APPENDIX H GOVERNMENT ARCHITECT'S ADVICE

RE: Revised PPR for Rozelle Village, Major Project Application (MP11-0015)

Rozelle Village, Major Project Application (MP11-0015): Design Review 2.

LEVEL 6,8,10,12,14,16,18,20 - LAYOUT DIAGRAM

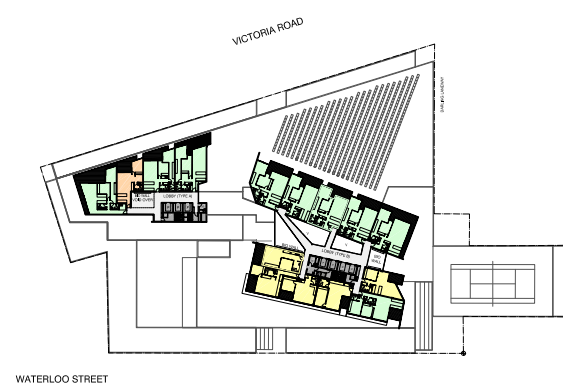
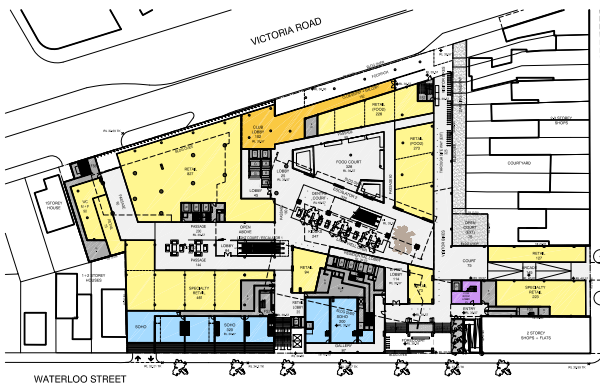
An ongoing concern is that some units are more than 10m deep, with inadequate natural light and ventilation to a number of 1 and 2 bed units. Some bedrooms are more than 4 metres from natural light.

- Changes to the tower separation are satisfactory.
- Changes to floor plates are not satisfactory:
 - The apartments are narrow and deep with bedrooms that are too far from natural light.
 - There has been no improvement in the design to offset the impact of the bulk.
- It is recommended that both tower floor plates be reduced to 22.5m x 28m (refer to Attachments 2 and 3).
- The rationale for this is based on:
 - a reduction of north facing units to a maximum 7.5m depth will match south facing units and will allow greater light penetration into units.
 - The recommended depth would, together with reductions in building height, result in more slender tower profiles.
